Date: 16 August 2023

Application Reference: 6/2022/2300/COND

Proposed development at: Beadles Volkswagen Van Centre Harpsfield Broadway
Hatfield AL10 9TF

Proposal: Submission of details pursuant to condition numbers - 1 (Construction Management Plan), 5 (Surface Water Strategy), 6 (Surface Water Scheme), 7 (Drainage), 8 (Foundation), 9 (Design Plan), 10 (Accessible Housing Scheme), 11 (Highway Improvement), 12 (Samples), 13 (Hard Landscaping), 14 (Soft Landscaping), 15 (Hard landscaping - roof garden), 16 (external lighting), 17 (Cycle Store), 18 (Cycle Store under-croft/Open air), 19 (Balcony Screens), 20 (Energy & Sustainability Statement), 21 (PV Cells Plan), 22 (Bat & Bird Boxes), 23 (Noise Compliance), 24 (Noise Compliance), 26 - (SuDS), 27 (Access), 28 (EV Charging Points), 29 (Parking), 30 (Bin Stores), 31 (Roof Gardens), on planning permission 6/2020/3222/MAJ

Figure 4: Bore Hole 1 (BH1)- Showing Strategy with Piling Profile

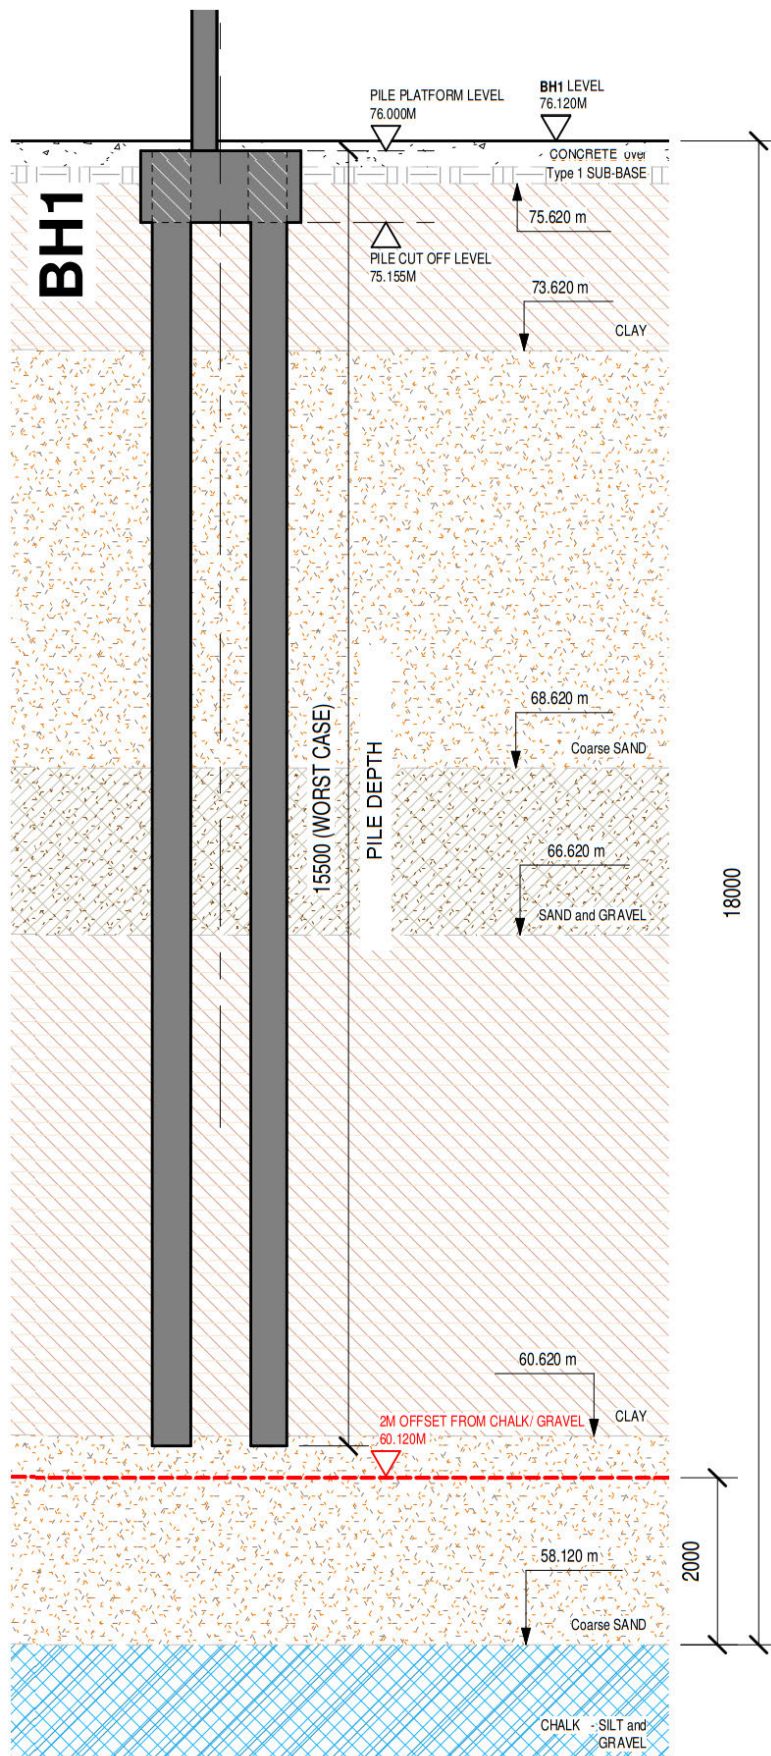
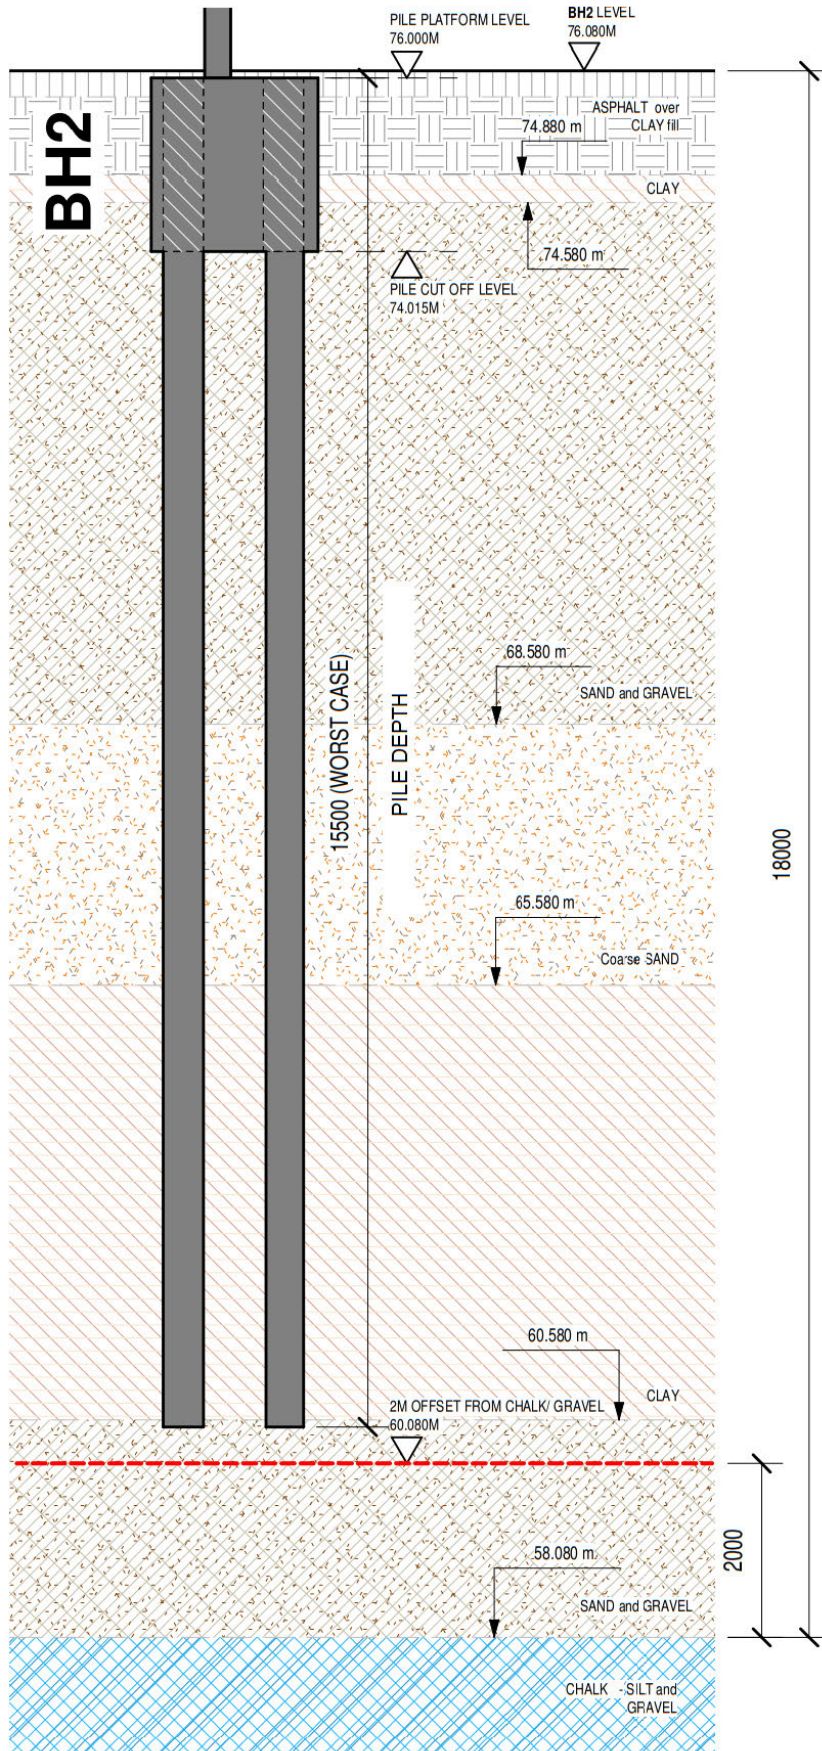
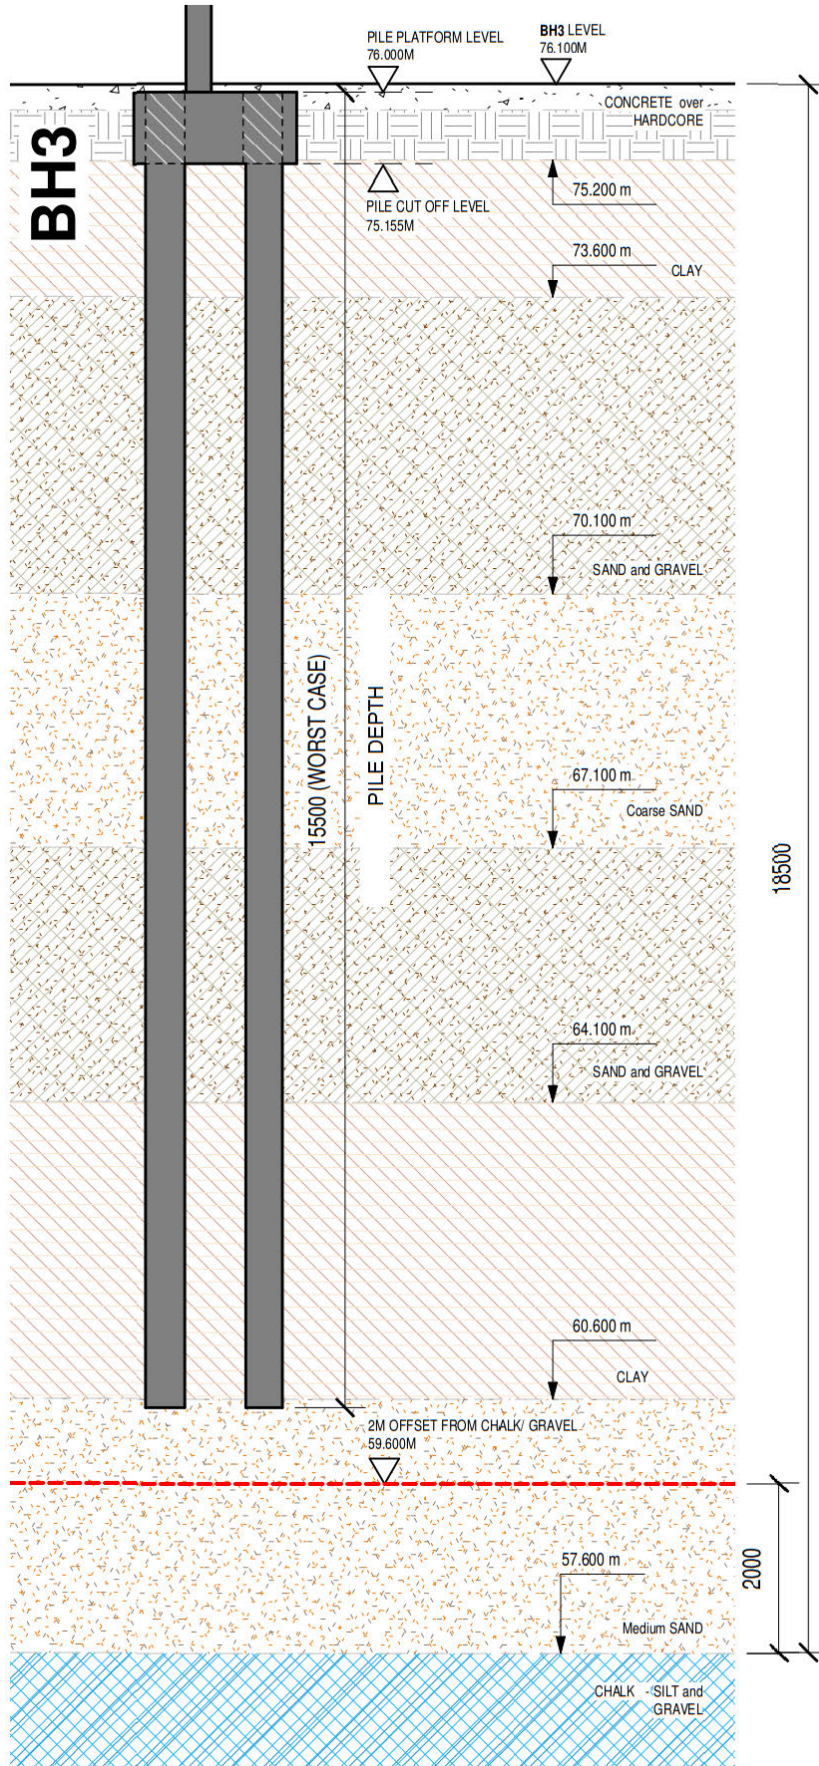
The proposed piling depth finishes at the top of the Lower Sand and Gravel aquifer which is hydraulically connected with the Chalk aquifer below (principal aquifer), and could cause contamination.

Figure 7: Locations of Bat and Swift Boxes

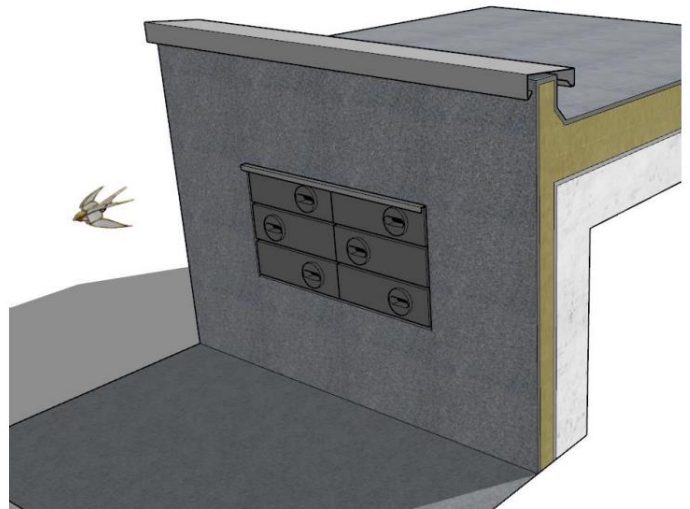
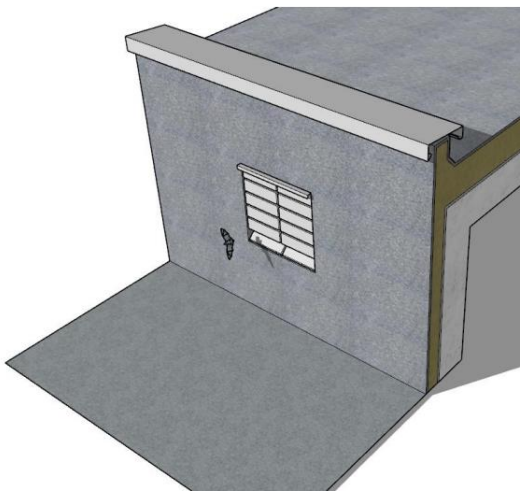
Notwithstanding the above, the details submitted under this condition would not have been discharged as the swift and bat box locations are not suitable.
